M25 junction 28 improvement scheme

10.12 Report on Proposed Scheme Changes 5-7

Regulation Number	Regulation 5(2)(q)
Planning Inspectorate Scheme Reference	TR010029
Application Document Reference	TR010029/EXAM/10.12
Author:	M25 junction 28 scheme, project team, Highways England

Version	Date	Status of Version
0	21 April 2021	Request for Changes 5-7, Deadline 6

Drawing Title:	<b>LAND PLANS REGULATION 5(2)(i) Sheet 1 of 4</b>
Drawing Number:	<b>TR010029/APP/2.2</b>
HE PIN: HE551519	Scale: 1:2,500
Original Size: A1	<b>4</b>

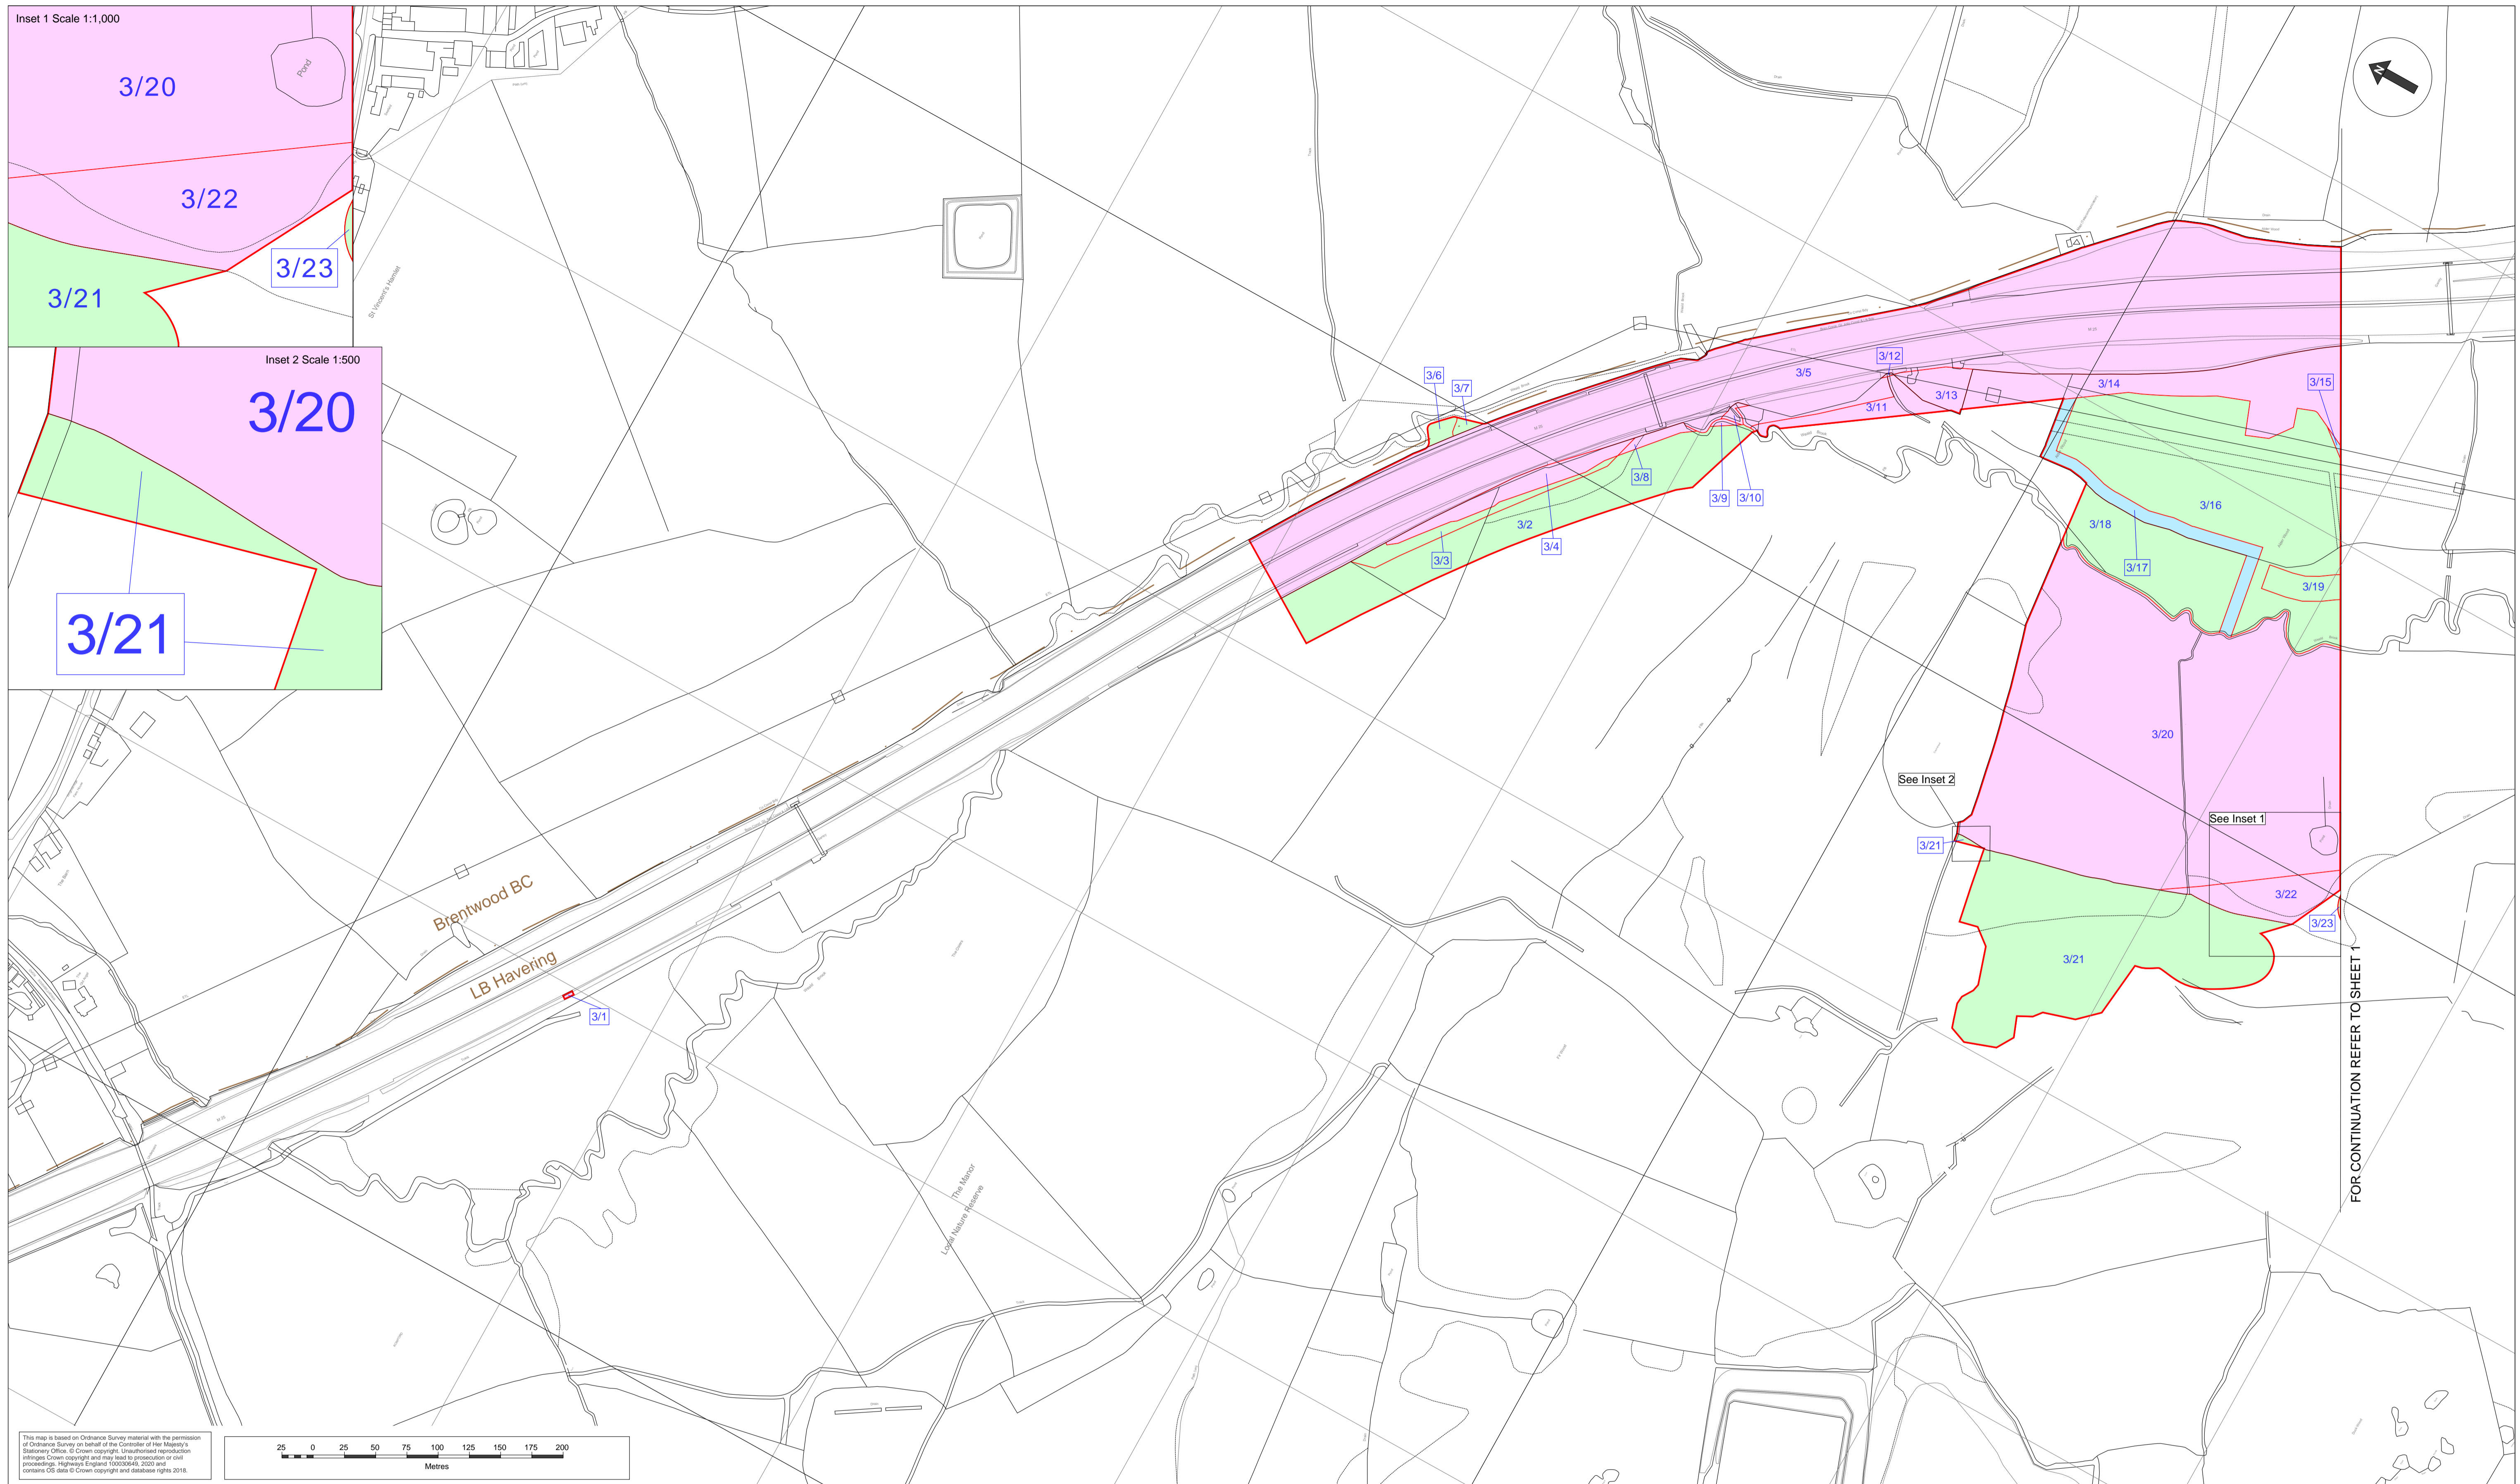
- 4.6.5 With the proposed change, the permanent acquisition of rights in plots 1/17, 1/21 and 3/19 are no longer required for Work No. 30 but temporary possession of these plots are required for access and construction works. Plot 1/21 will be split into two plots, one remaining as permanent acquisition of rights to enable the maintenance of Work No. 22 (new drainage outfall pipe) and the remainder (new Plot 1/21a) required for temporary possession associated with the realignment of Weald Brook. Plot 1/23 is no longer required. Whilst it will remain within the Scheme Order limits it will be coloured orange to show that no land powers are sought in respect of it.

- 4.6.6 Refer to the revised Land plans ((TR010029/EXAM/10.13), Book of Reference (TR010029/EXAM/10.14) and Schedule of Changes to the Book of Reference (TR010029/EXAM/10.15) submitted with this Change Request which shows the plots that are required for Work No. 30 and the land powers sought which are affected by Change 6.

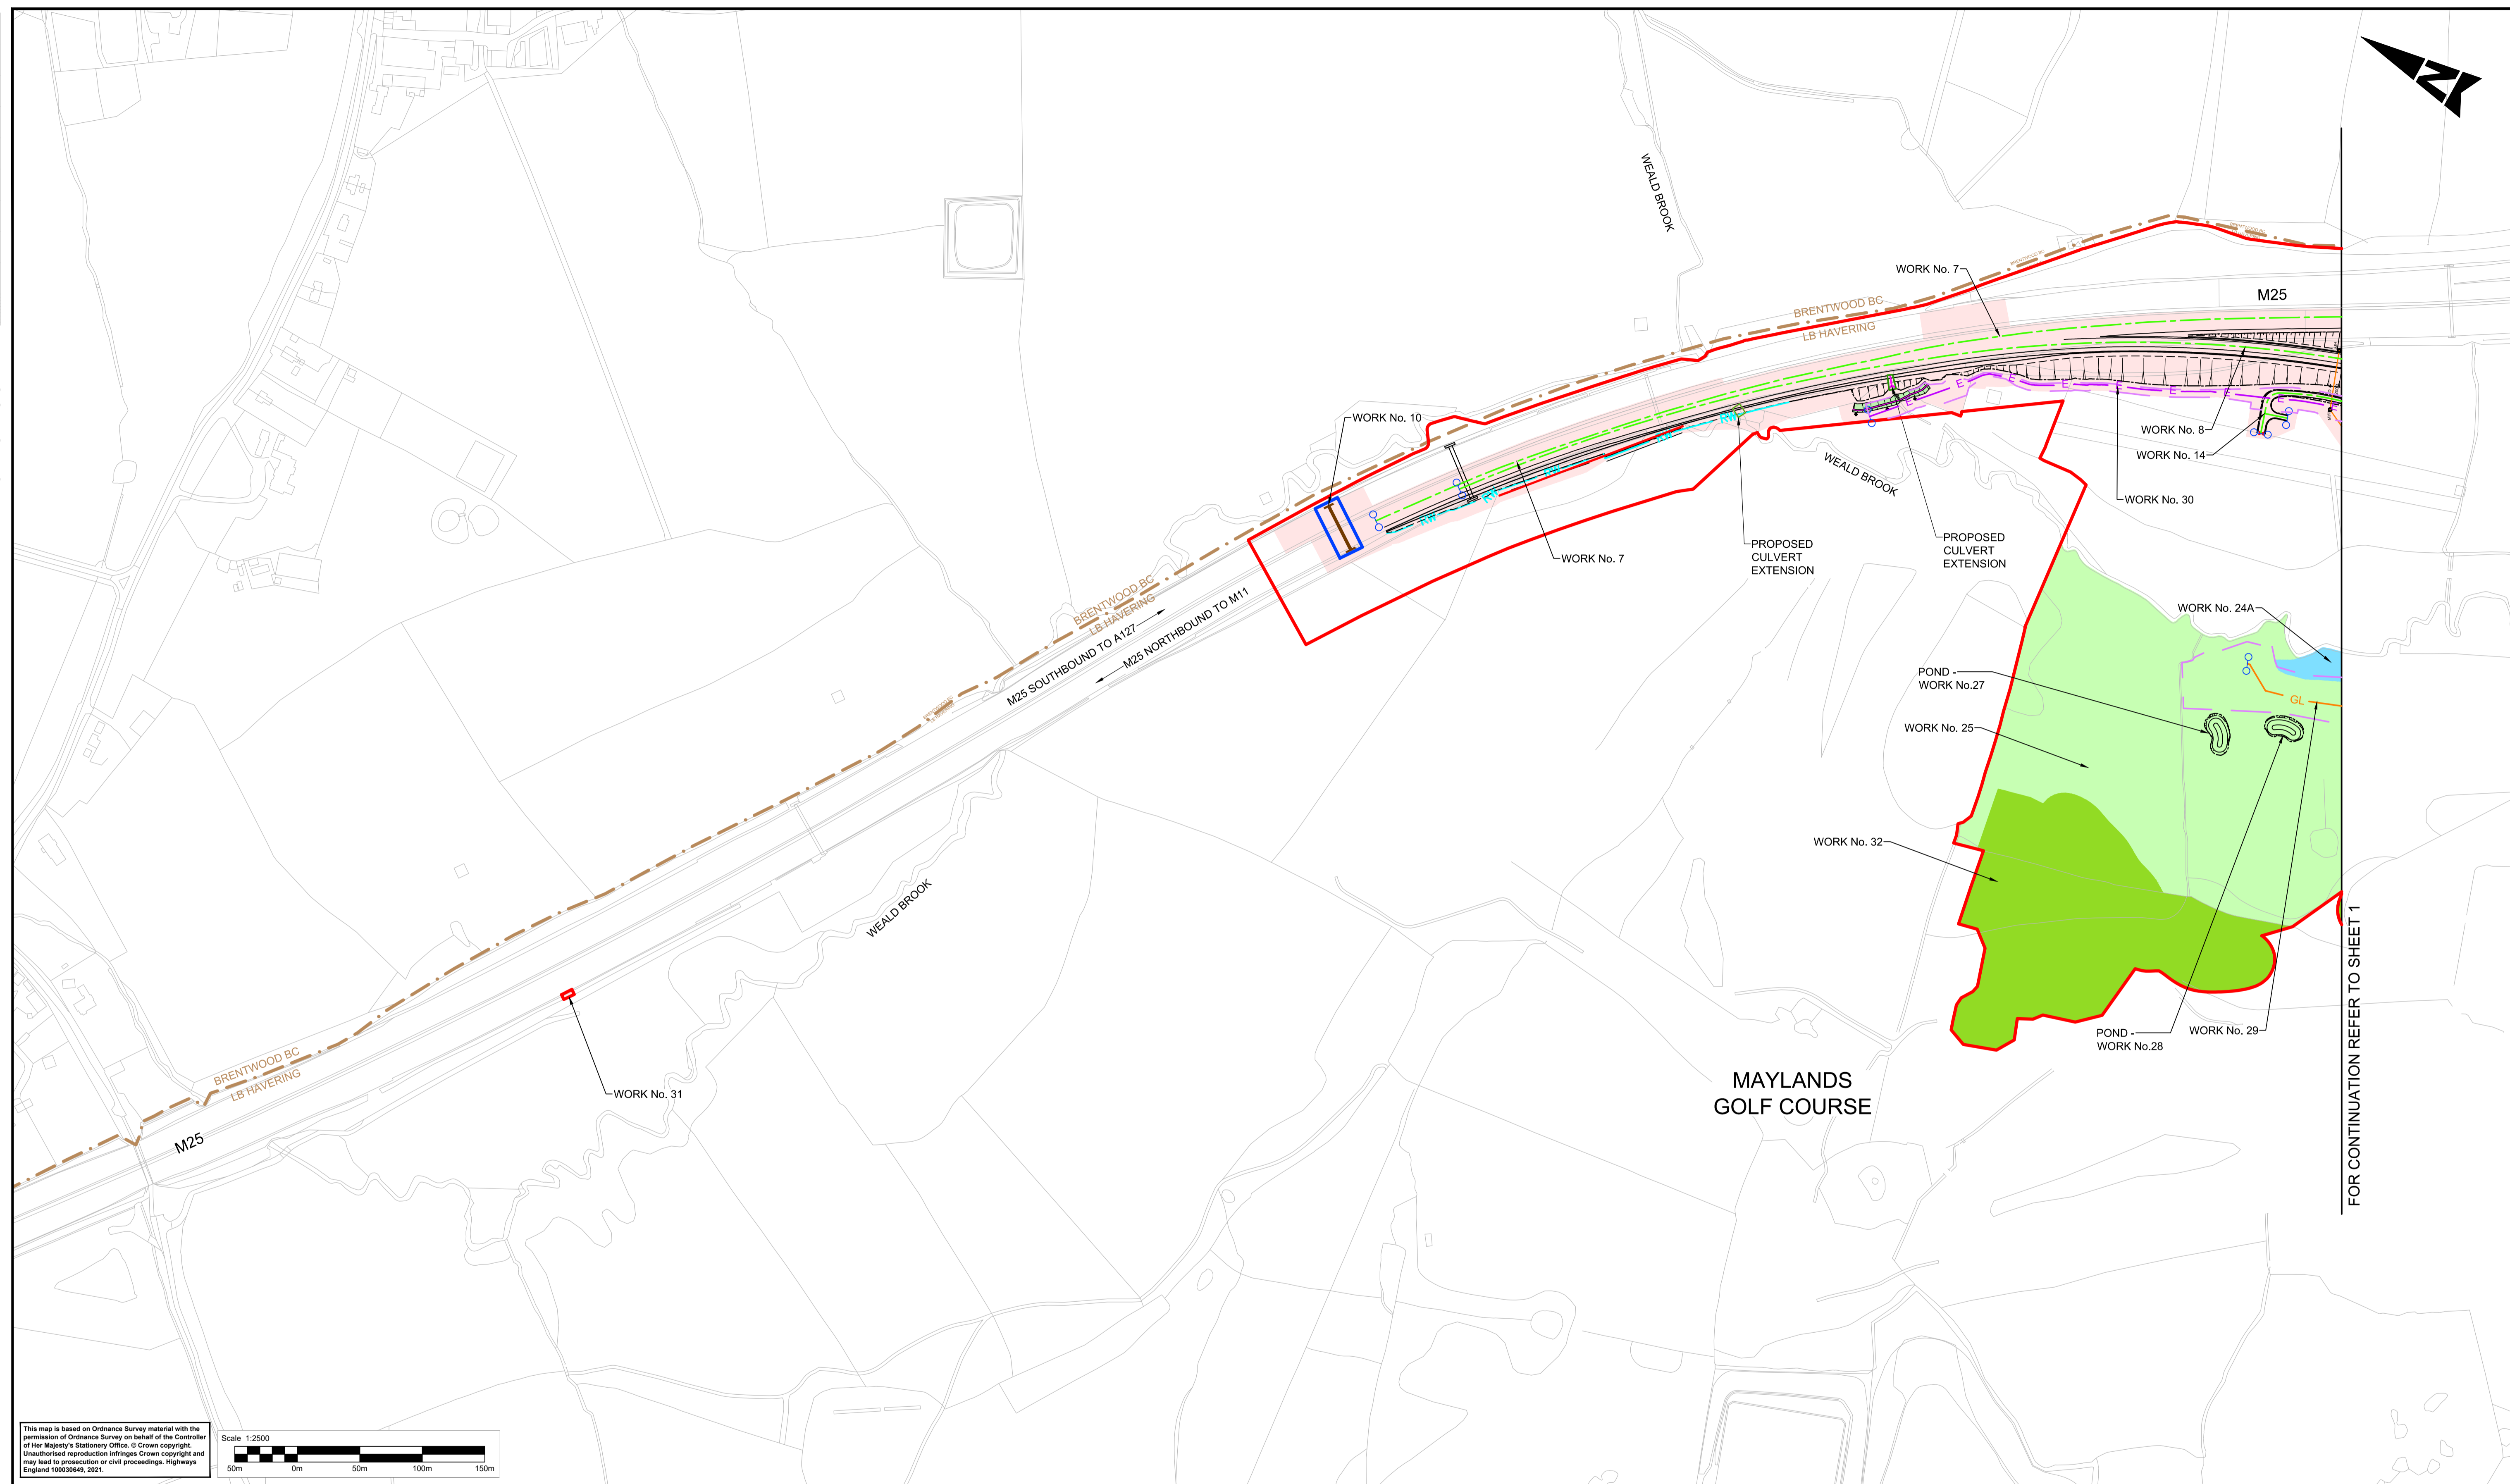
4.1.1 This change is to the realignment of the diversion underground of an existing 11kV overhead electric line owned and operated by UKPN approximately 640 metres long (Work No. 30). In the Application the diversion commences at a point situated south of the loop road (Work No. 6) in proximity of the proposed Grove bridge, and terminates approximately 120 metres north of the loop road and Duck Wood bridge as shown on sheets 1 and 3 of the Works plans (REP5-003).

4.1.2 Change 6 is to revise the alignment for the cable diversion – which would still be below ground – moving it closer to the M25. The diversion would commence at UKPN’s substation on the M25 northbound on-slip near the Brook Street roundabout and terminate at UKPN’s existing underground cable adjacent to the Weald Brook culvert to the west of the M25.

4.1.3 The underground cable requires a 3 metre wide easement which means that the revised realignment would affect some sections where woodland replacement planting is currently proposed. The proposed woodland planting will be replaced elsewhere within the Scheme and small shrub and grassland species will be planted within the easement as far as practicable.
